From: [REDACTED]
Sent: [REDACTED]
To: Iqraa Malik
Cc: 'Paul Samme'
Subject: RE: K/20/21/HH - 2 Gorse View Peak Lane Kingston BN16 1RW
Attachments: We sent you safe versions of your files; PLANNING page 2 - 2 Gorse View.pdf

Proposed Block Plan
Scale 1 : 200

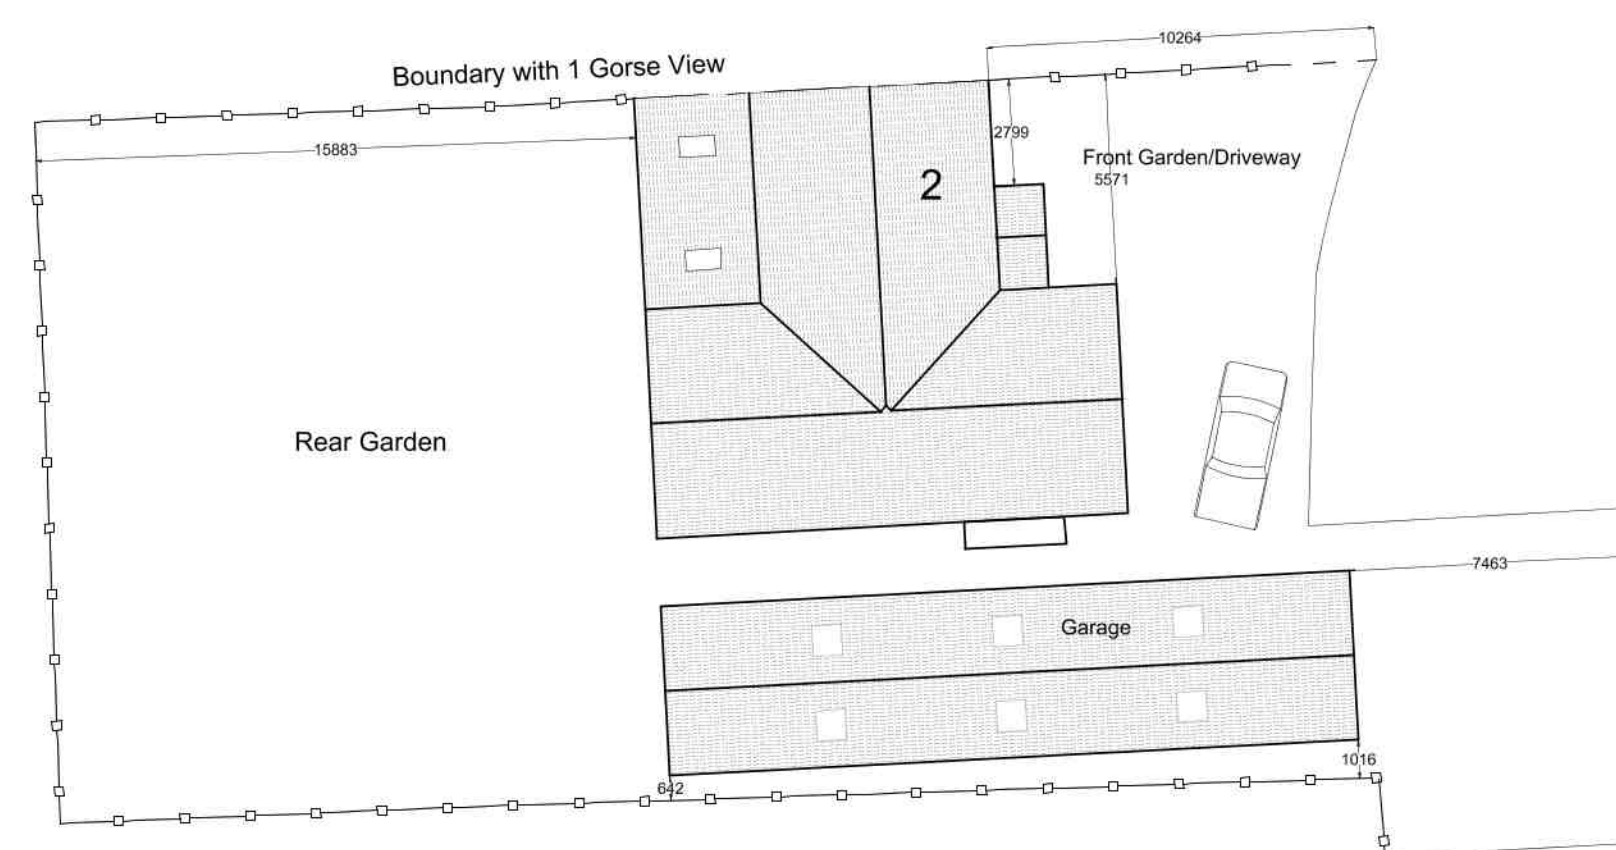
Apologies I forgot to mention in my previous email, the dimensions to the front and rear boundaries are also required.

Amended drawing attached showing dimensions to boundaries.
Forms are being sent to you directly from the applicant.

Proposed First Floor Plan
Scale 1 : 100

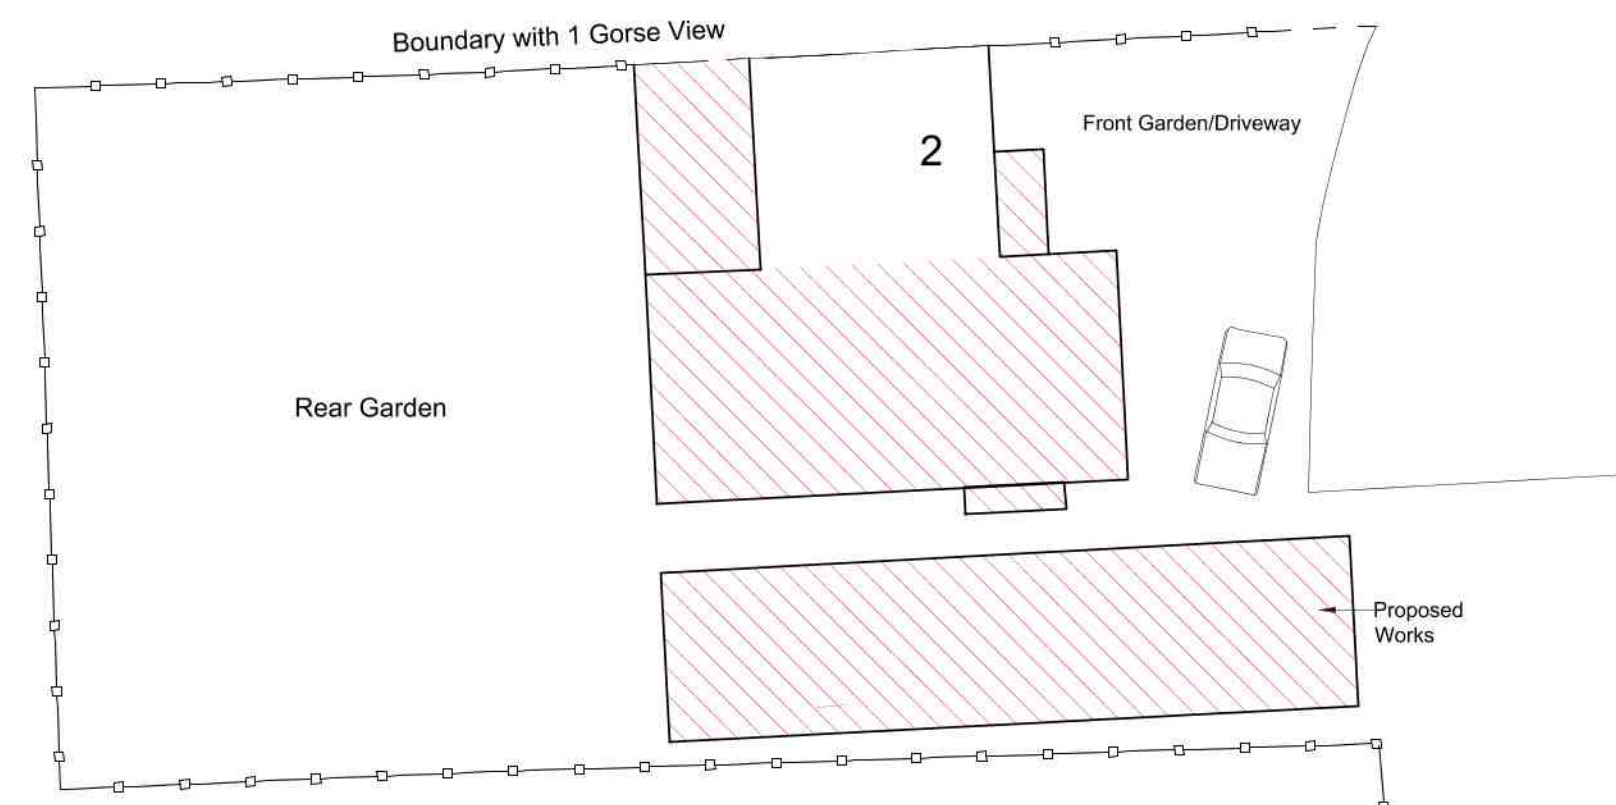
Thank you for providing the forms. However, the labels on the plans still need amending as the existing and proposed first floor are listed as ground.

Thank you for providing the additional information. However, the existing and proposed first floor plans are labelled as ground floor. Please amend.

Amended drawing attached.
